Our ref: WA/2019/126896/01-L01
Your ref: 19/00214/DISC
Date: 21 August 2019

Partial discharge of conditions 13 (positioning of bicycle and bin stores), 24 (design and construction details), 25 (final surface treatment), 31 (landscape design), 53 (site levels) and 84 (ecological construction method statement) of 10/01780/hybrid

Bicester Eco Town Exemplar Site Banbury Road Bicester

Environment Agency Position – Condition 84

**Boardwalk Construction  
Details**

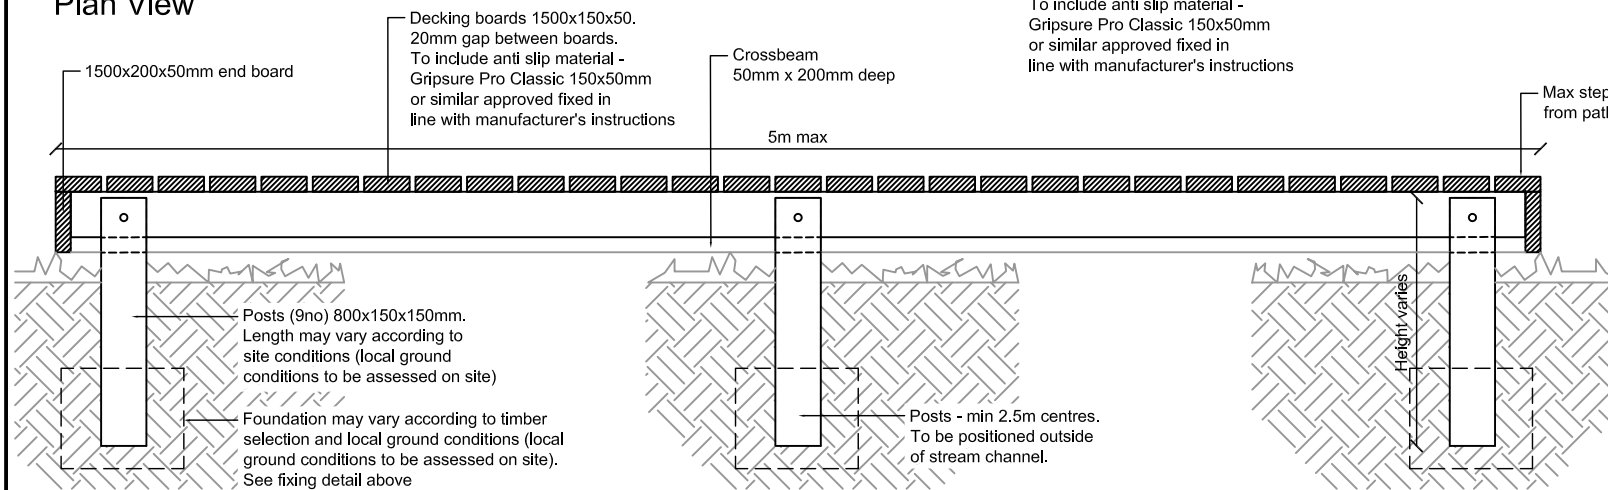
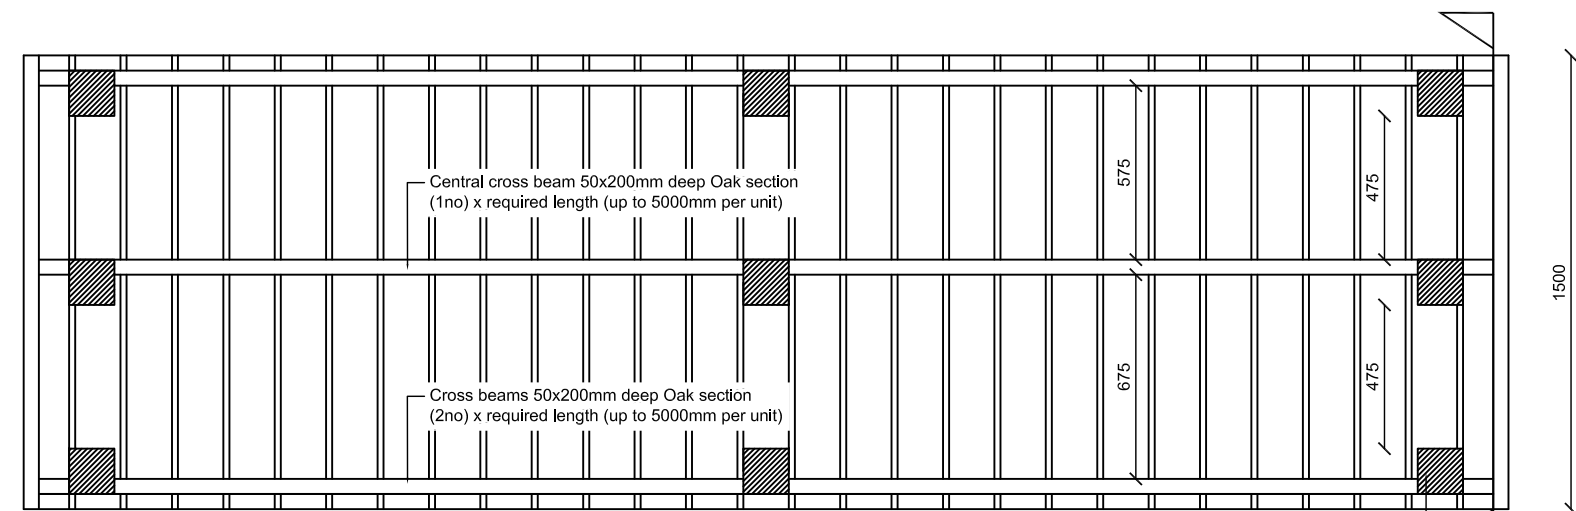
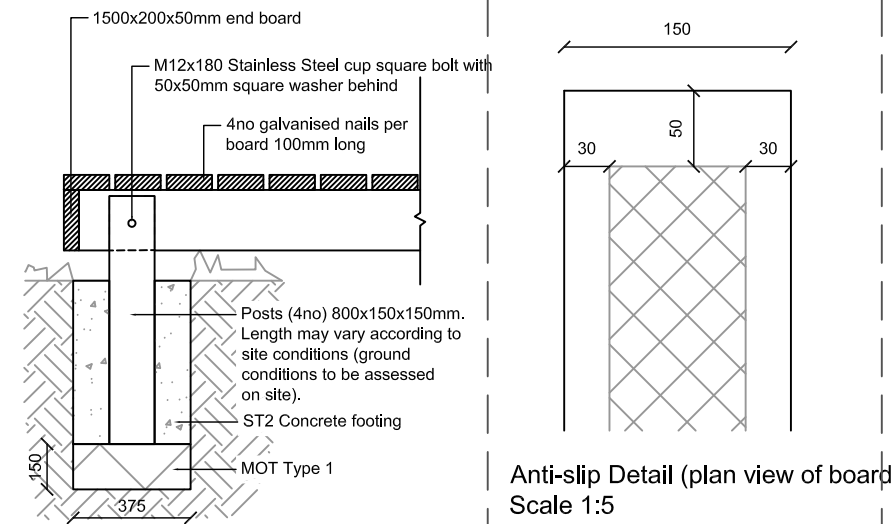
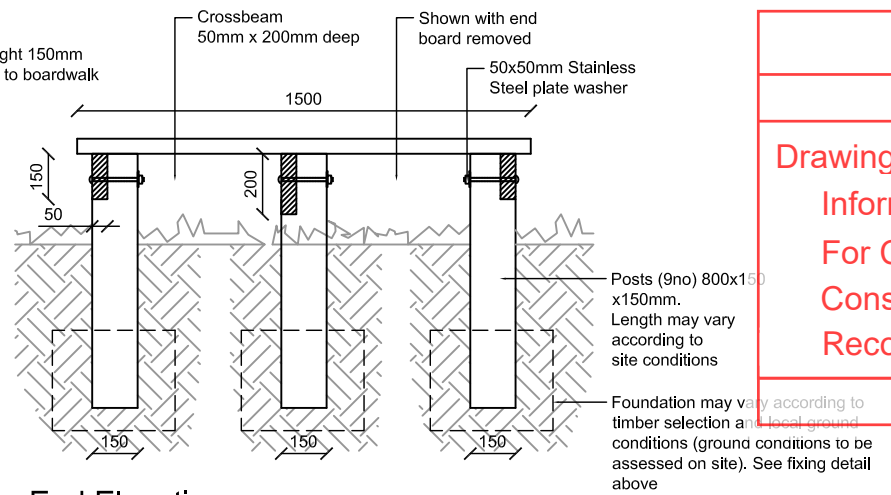
We are not satisfied that the proposed bridge will be set above the 1% annual probability flood event with an allowance for climate change and a minimum 600m freeboard. The plan referred to in this submission, 701-809-UA001881-03, illustrates the position of the soffit, but no dimensions or measurements have been submitted illustrating the position of soffit levels in relation to the watercourse and 1% annual probability flood event level plus the climate change allowance. As this is a predominately residential scheme we would expect an allowance of 35% to be used unless a different allowance can be sufficiently justified. It is therefore difficult to determine whether the bridge soffit is appropriate to avoid causing an increased risk of flooding and erosion in a future of climate change.

The plans provided do not show the position of the abutments in relation to the natural bank and watercourse. The amount of encroachment into the channel and obstruction to the natural flow regime of the watercourse posed by the proposed bridge is also unclear. Abutments should be set at least 1m back from the top of the bank and be wide enough apart to function under flood conditions. This may require flood modeling to demonstrate flow capacity.

The plans provided illustrate that the proposed bridge design is to incorporate three piers. Piers can modify the natural flow regime of the watercourse and increase local flooding and contraction scour. To ensure the flow of the watercourse is not obstructed and to maintain a natural watercourse corridor we require bridges of a clear-span design.

The drawings provided appear to show a loss of natural bank, encroachment into the channel (through the abutments and pillars). There has been no information submitted

- Show in plan 701-809-UA001881-03, with dimensions/measurements, that the soffit level of the bridge shall be set 600mm above the 1% annual probability flood event with an appropriate allowance for climate change (35%).

- Provide more detail for the design and location of the bridge, particularly;
 - the location of the abutments set back from the top of the bank a distance sufficient to avoid an increase in flooding and impacts to biodiversity (see reason 2 below);

- removal of the piers from the design to be replaced with a clear-span design. The clear span design should be used unless it can be shown to be impracticable and an alternative design justified; and

- demonstrate the capacity of the bridge during flood events. Flood modeling may be required to demonstrate that the design of the bridge will not interfere with natural flows or increase the risk of flooding in a future of climate change.
